## KITTITAS COUNTY COMMUNITY DEVELOPMENT SERVICES

January 27, 2009

### RE: McGrath Short Plat (SP-08-00050)

Kittitas County Community Development Services hereby grants **conditional preliminary approval** to the McGrath Short Plat (SP-08-00050), subject to the following conditions:

McGRATH SHORT PLAT - NO. SP-08-00050
LOCATED IN SECTION 32, T-18 N, R-20 E, W.M.
KITITITAS COUNTY, WASHINGTON

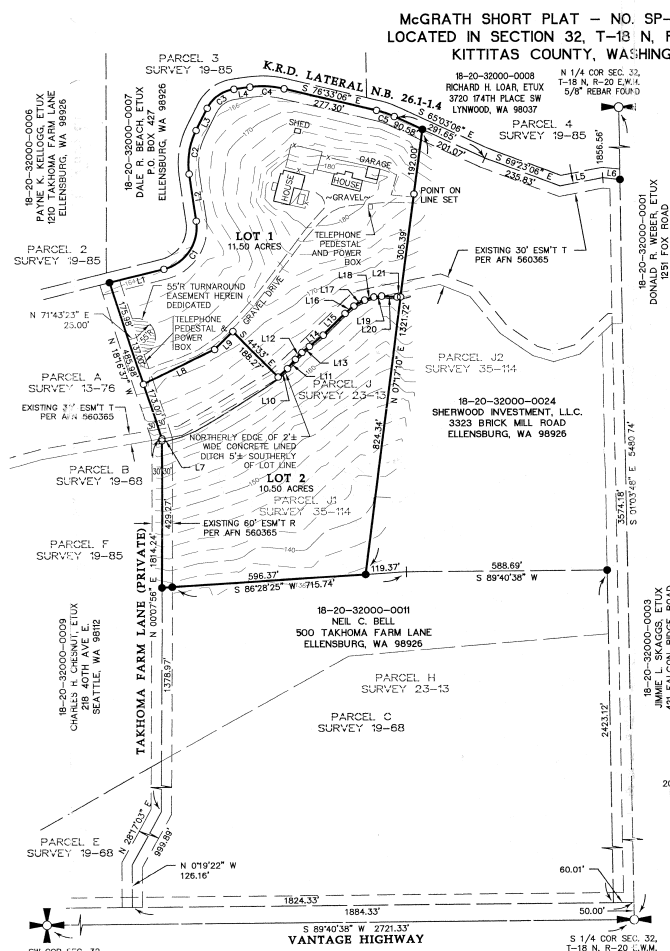
1. Both sheets of the final mylars shall reflect short plat number SP-08-00050 and an accurate legal description/map numbers shall be shown on the face of the final plat.
2. Full year's taxes must be paid on all tax parcel numbers pursuant to the requirements of the Kittitas County Treasurer.
3. One-time split provision. These properties have exhausted the use of the one-time split provision provided by KCC 17.31.040. No further division of this property will be allowed.
4. Plat Note "C." shall be removed pursuant to requirements from Kittitas County Public Works.
5. Replace plat note "H." with the following language:

6. The remaining plat notes submitted on the preliminary drawings shall also be submitted on the final mylar drawings. Additionally, the following plat notes shall be added to the final mylar drawings:

The approval of this division of land includes no guarantee that there is a legal right to withdraw groundwater within the land division. The approval of this division of land provides no guarantee that use of water under the ground water exemption (RCW 90.44.050) for this plat or any portion thereof will not be subject to curtailment by the Department of Ecology or a court of law.

- All development must comply with the International Fire Code (IFC) and its appendices.
  - All lots of the McGrath Short Plat SP-08-00050 shall share a single ground water withdrawal of no more than 5,000 gallons per day. No more than a total of ½ acre of lawn and garden shall be irrigated from this ground water withdrawal for both lots.

- Metering will be required on all residential well connections and metering results shall be recorded in a manner consistent with Kittitas County and Washington State Department of Ecology requirements.

- The subject property is within or near existing agricultural or other natural resource areas on which a variety of activities may occur that are not compatible with residential development for certain periods of varying duration. Agricultural or other natural resource activities performed in accordance with county, state and federal laws are not subject to legal action as public nuisances. Kittitas County has adopted right to farm provisions contained in the Section 17.74 of the Kittitas County Zoning Code.
